STATEMENT ON BEHALF OF IRISH LIFE ASSURANCE PLC. ('ILA') BY CONOR SHEEHAN BL MRTPI

MODULE 1 – Metrolink Hearing – 4th March 2024

My name is Conor Sheehan BL MRTPI. I am part of a team making a submission to the Board relaying ILA's concerns about the impacts of the metro tunnel on their newly constructed Cadenza office development, which is located at the junction of Earlsfort Terrace and Adelaide Road, close to the proposed southern terminus for Metrolink at Charlemont.

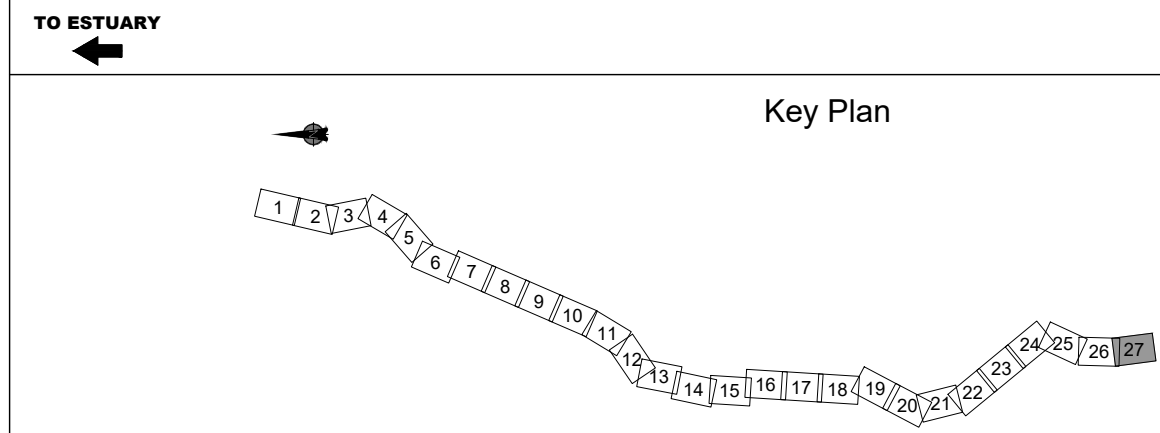
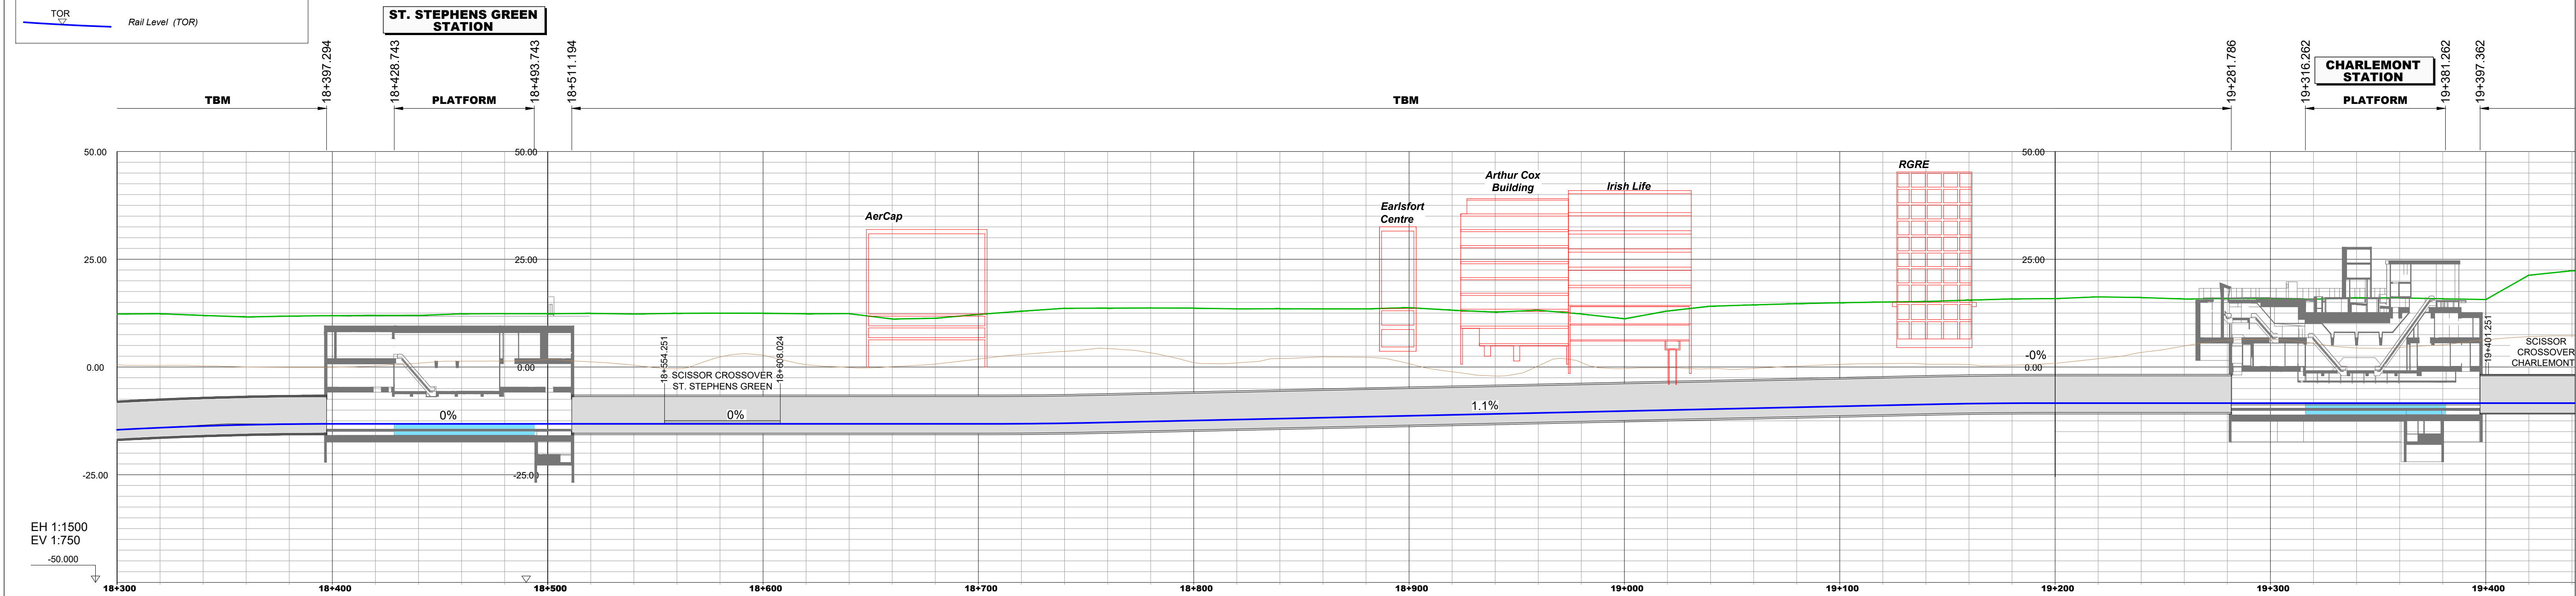
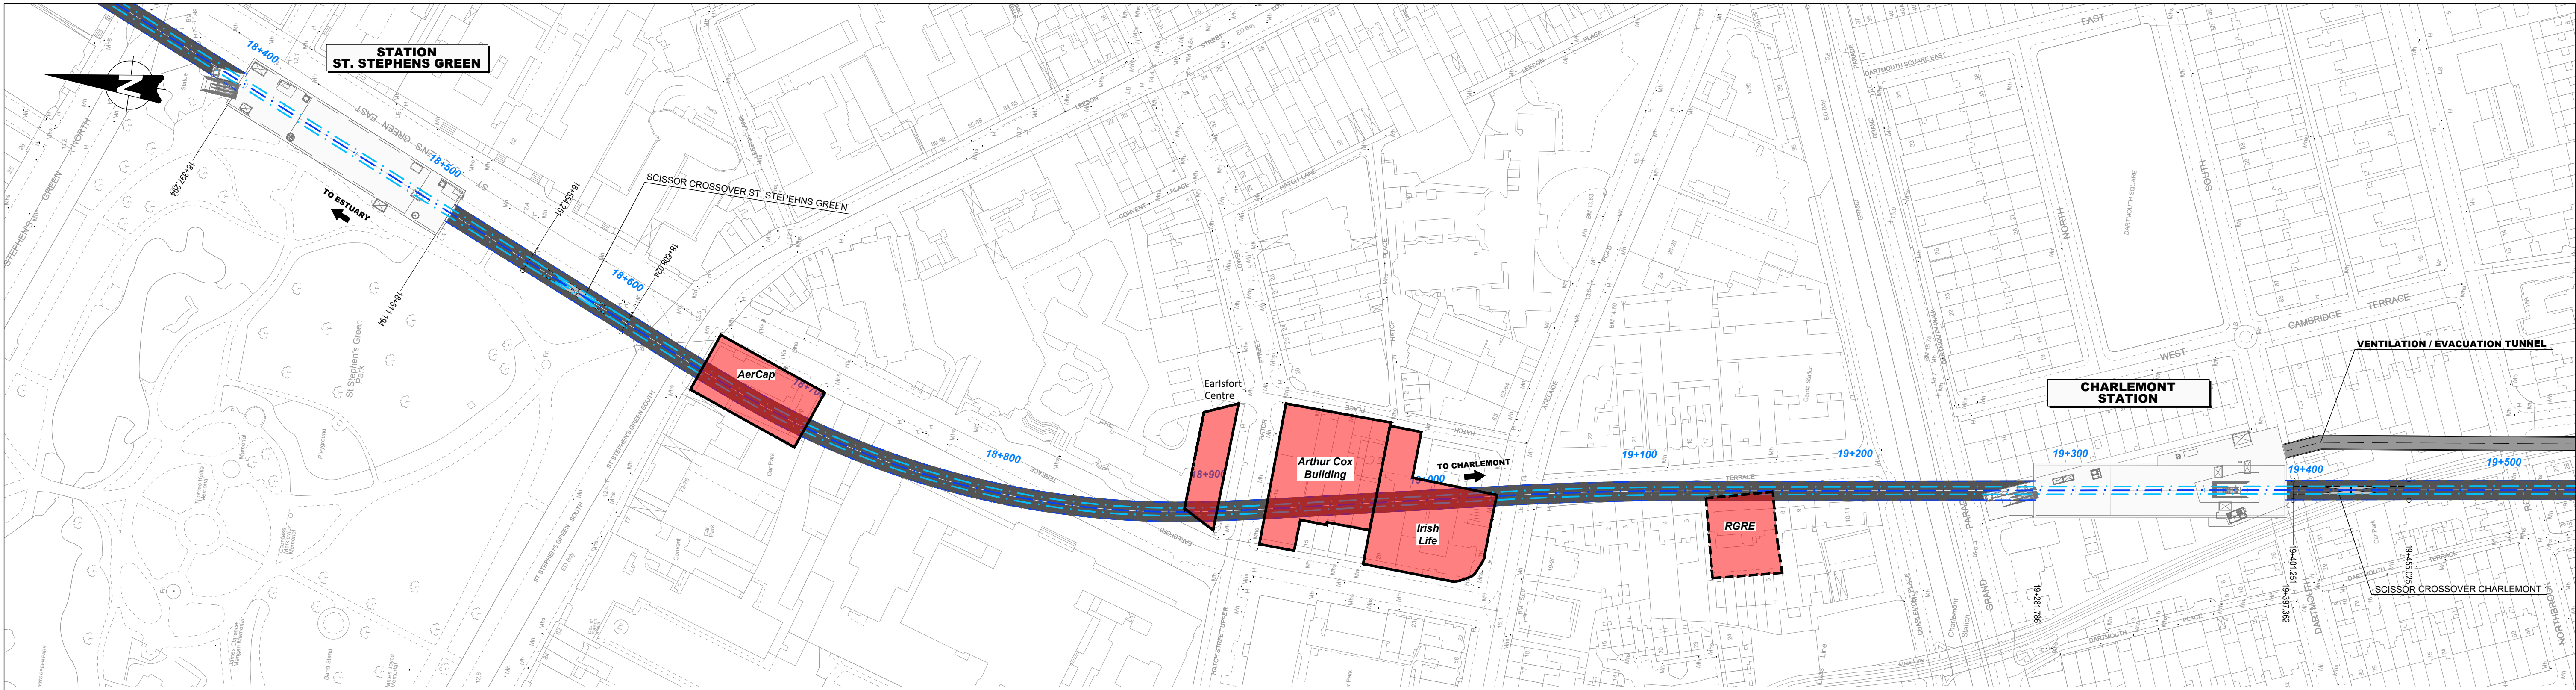
Irish Life requests that tunnel be diverted away from the building and/or it be located deeper underground if this will address the matters arising under items 1-5 above.

Can the tunnel be lowered to a degree that it will not cause damage and not have unacceptable noise and vibration impacts to the Cadenza building?

We hope that ILA's concerns can be addressed by altering the alignment and deepening the tunnel. As it stands there is a direct impact on anti-floatation anchors which is not acceptable to ILA.
